**Application by Fosse Green Energy ("the Applicant") for an order granting Development Consent ("DCO") for the Fosse Green Energy Project ("the draft Order") Application Reference: EN010154 ("the Application")**

**Fosse Green Energy Limited (the "Applicant") Development Consent Order (EN010154) (the "Application")**  
**British Pipeline Agency Limited ("BPA") responses to the Applicant's responses to the post-hearing summaries (Revision 1) (REP2-032)**

## Tech Note: Fosse Green 400kV FINALINE Cable Crossing

FIGURE TITLE
400KV PIPELINE CROSSING
FIGURE NUMBER
Figure 1-1
REV.
01

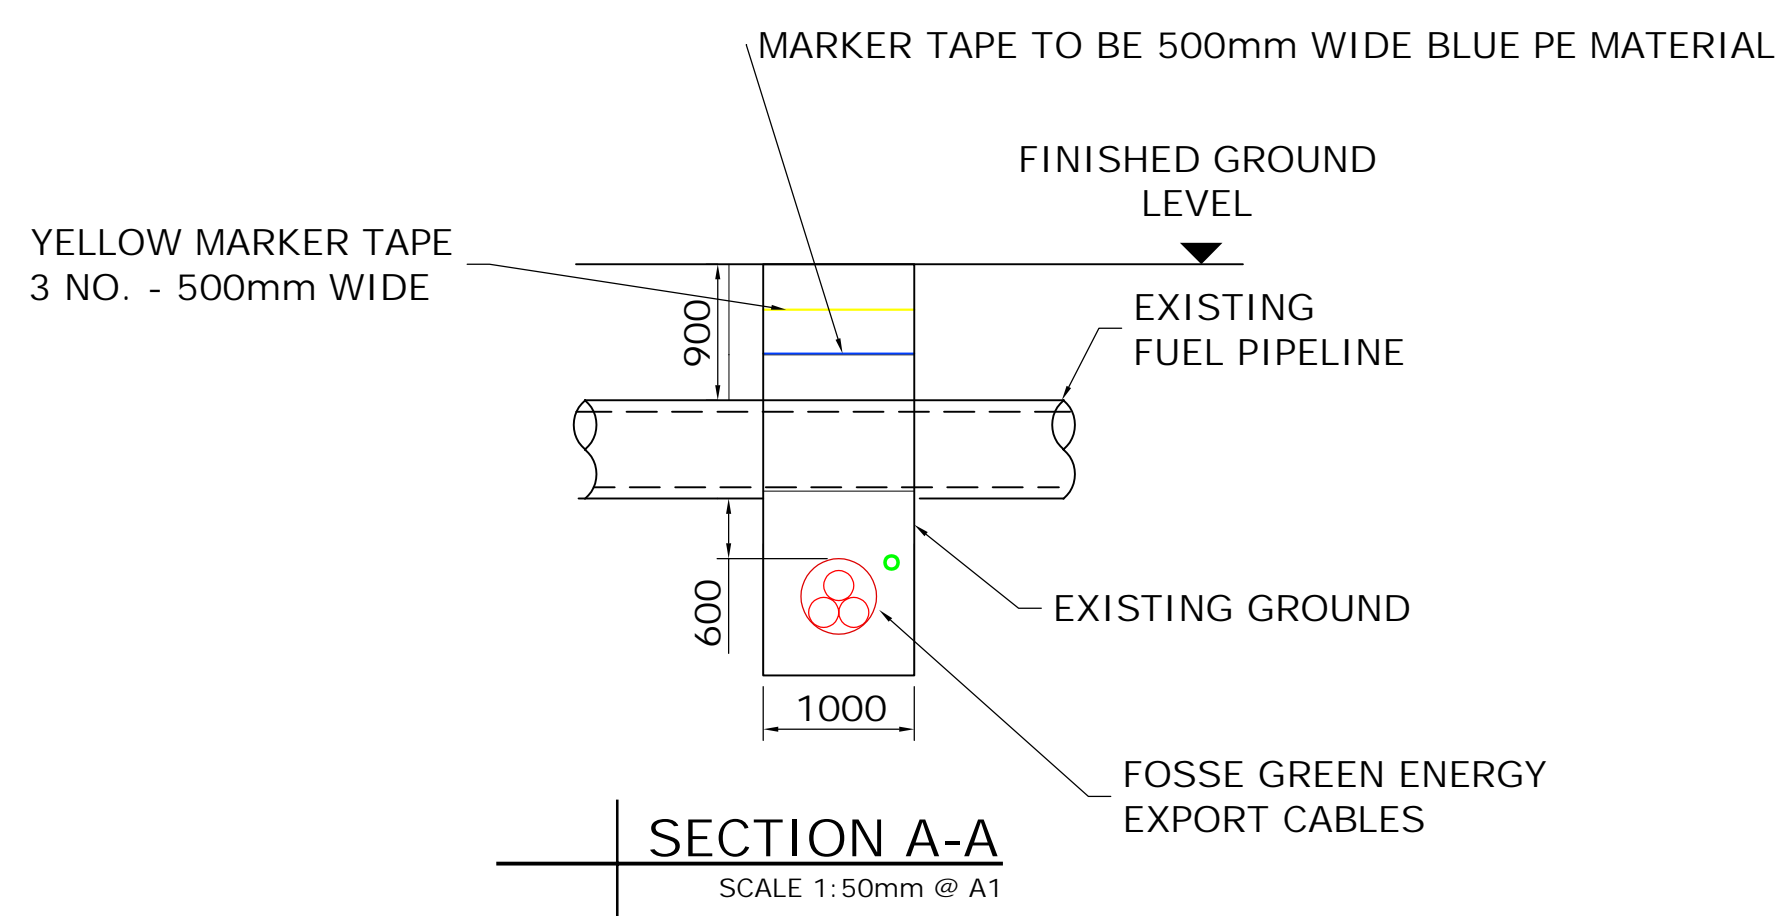
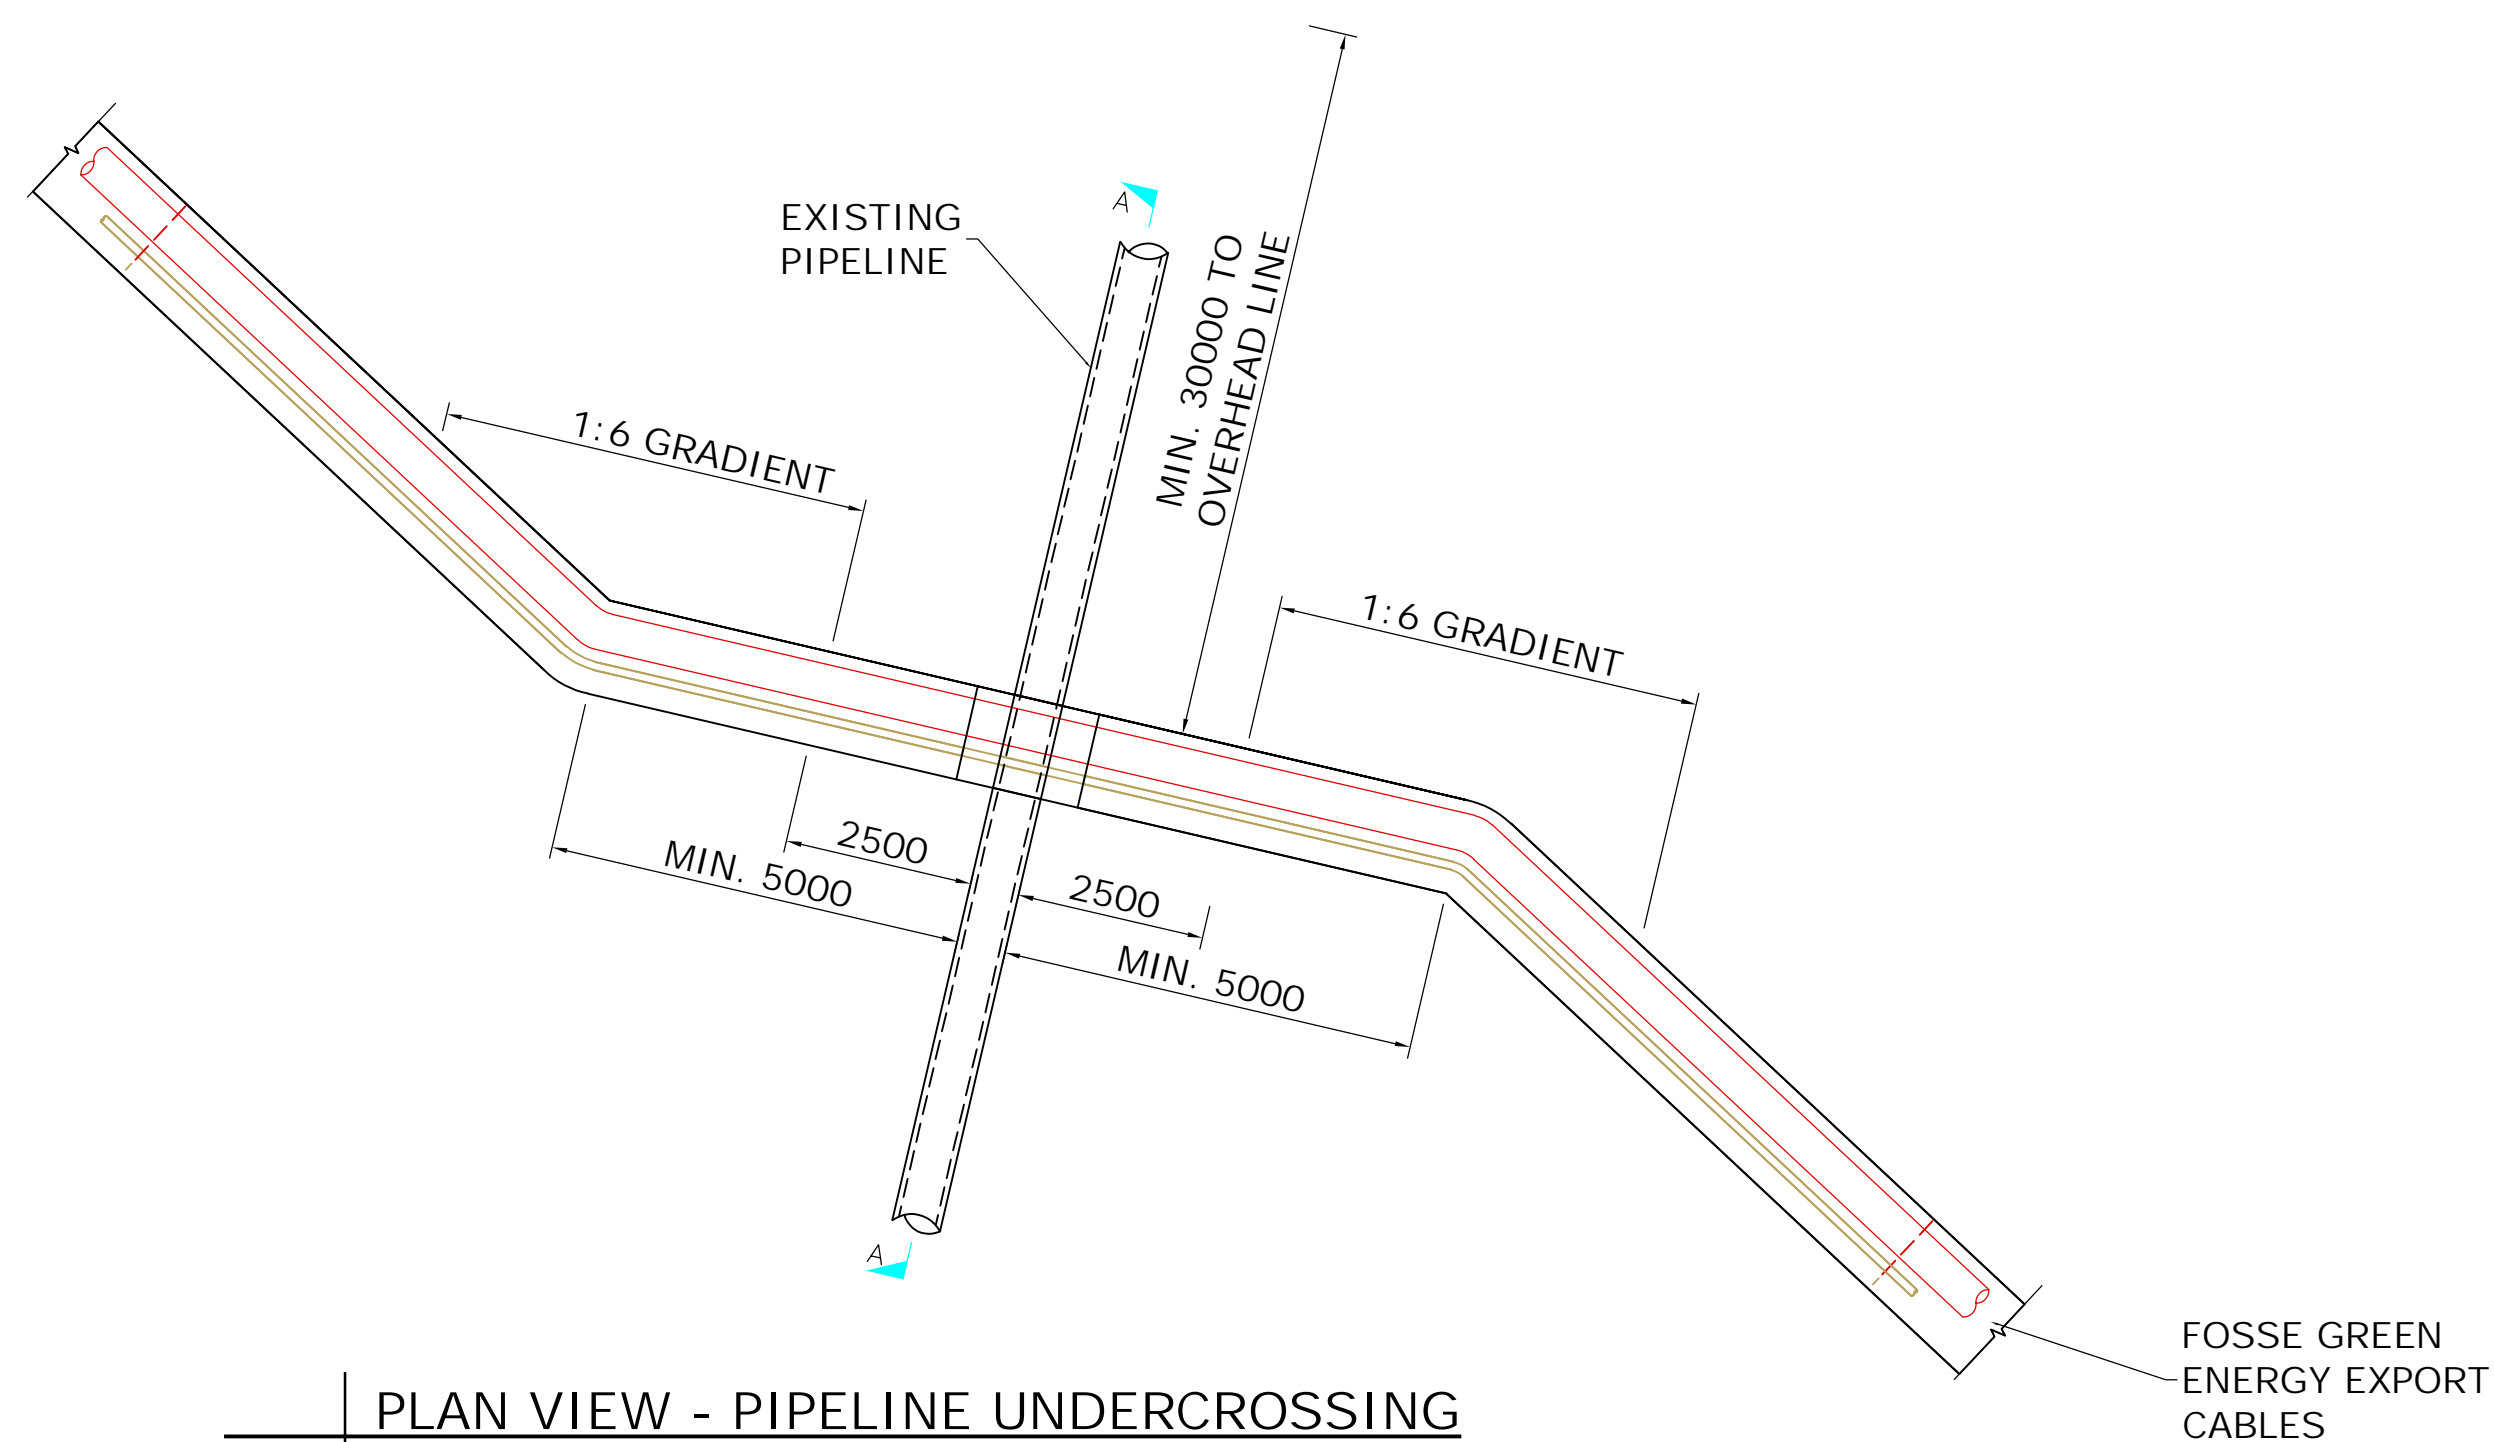
The proposed 400kV buried cable from Fosse Green will cross FINALINE to the west of Navenby and will cause an electrical interaction on FINALINE. This tech note outlines BPA safety concerns related to the electrical interactions from the development.

<sup>1</sup> Crossing angle based on measured angle in crossing diagram in AECOM Fosse Green Energy 400 kV cable – pipeline crossing technical note

- iv) Springwell Solar Farm (600MW) increasing load in iii)
- 3) The AC current density calculation used to produce figure 3 of rev 1 of AECOM report is not correct as it's not calculated for a 1cm<sup>2</sup> coating defect as required for the 30A/m<sup>2</sup> AC current density criteria (detailed in BS EN ISO:18086). The correct calculation is equation 1 in rev 1 of AECOM report and using this calculation the AC current density exceeds the 30A/m<sup>2</sup> criteria. This shows that with the development as planned the FINALINE would be at risk of AC corrosion

- a) Reduce electrical interference on FINALINE (preferred approach)
  - i) Cross FINALINE perpendicular
  - ii) Increase separation at crossing
  - iii) Avoid crossing nearby to existing sources of electrical interference
- b) Manage electrical interference (secondary approach) by installing zinc ribbon AC mitigation systems and enhancing pipeline monitoring
